RE: Vacation of Private Easement

Sketch Plat review and DFT comments for a vacation of an existing sewer easement and

granting of a new private access easement was reviewed on May 1, 2024 (PR-2020-004622_PS-2024-00078). Below are how the comments have been addressed:

**SKETCH PLAT OF
UNM GIBSON COMMERCIAL DISTRICT
- VACATED EASEMENT EXHIBIT -
JUNE 2025**

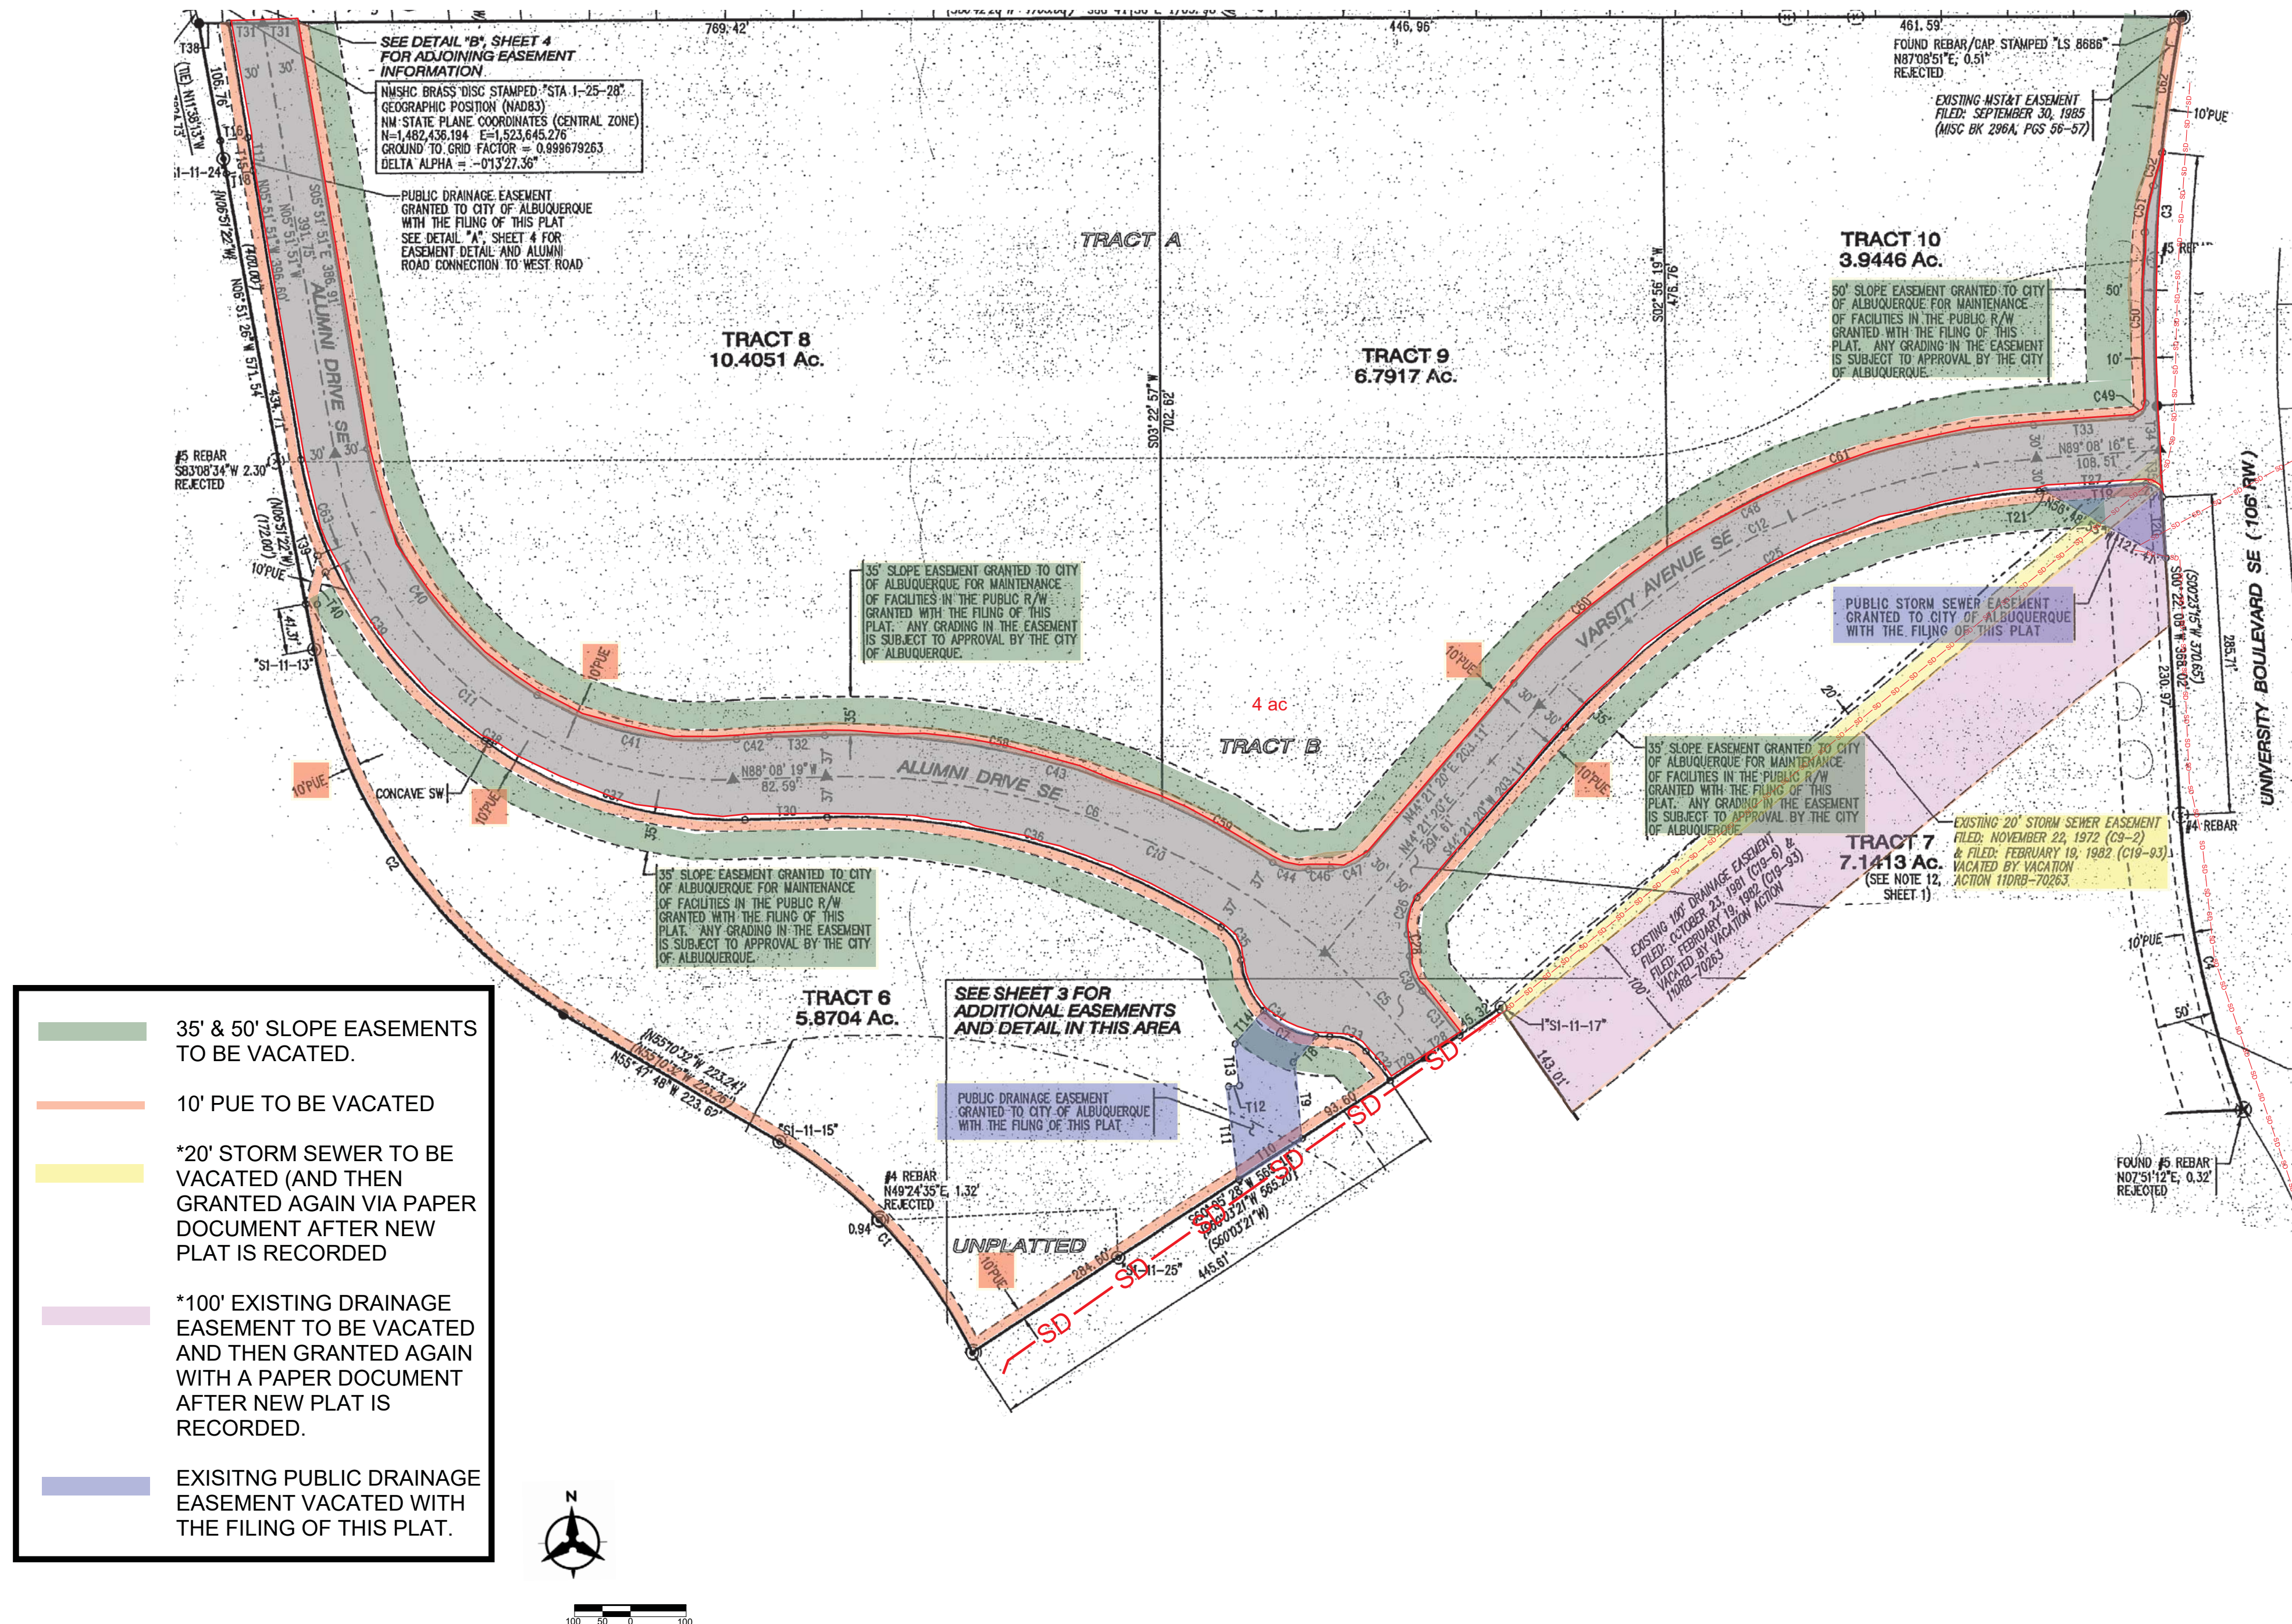
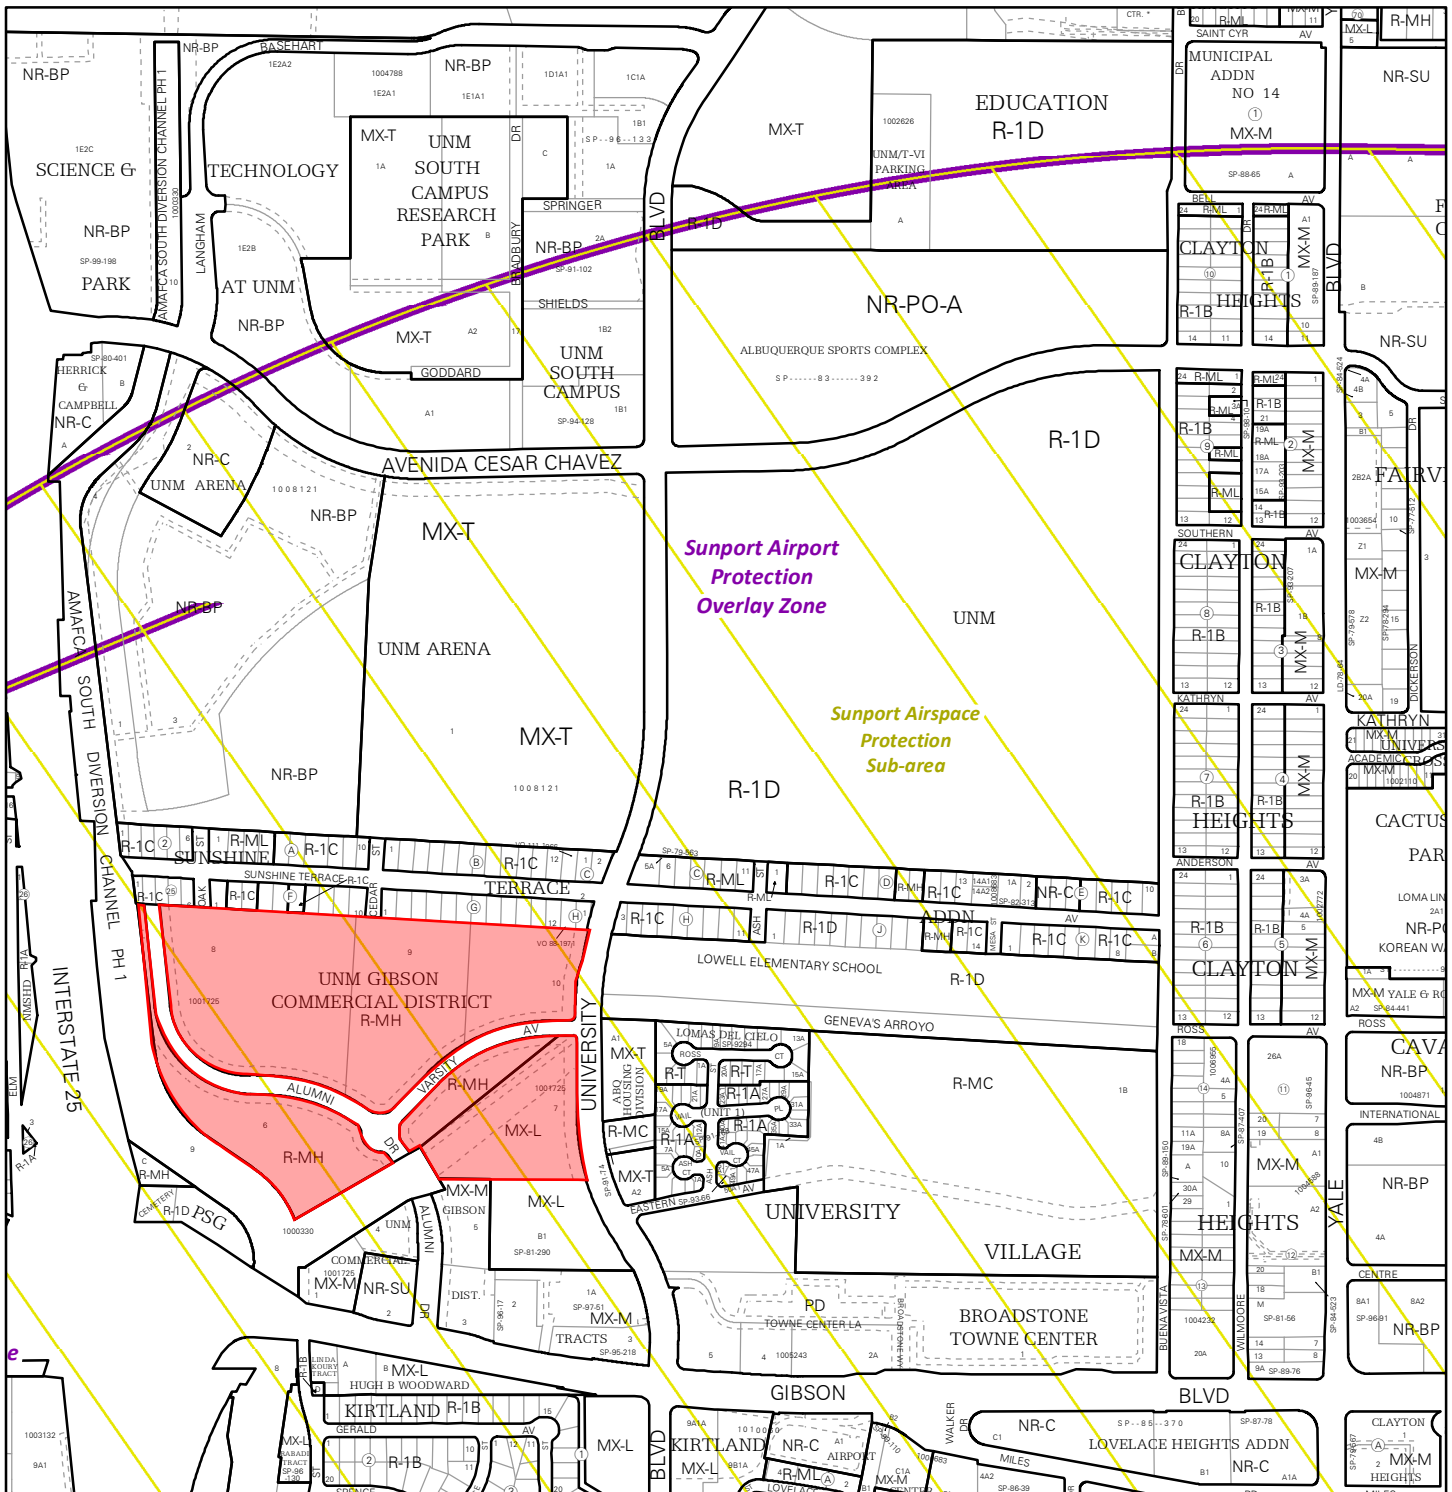
2. Please provide a surveyed exhibit showing the new realigned sanitary sewer and how it lies within the proposed easement.

Applicant Response: The new Sanitary Sewer Easement was granted via a paper easement (Doc# 202401391). This document has been included in this application. This approved easement has been indicated on this plat (See "Keyed Easement Notes [A]"). See Exhibit 1 – Sanitary Sewer Realignment.
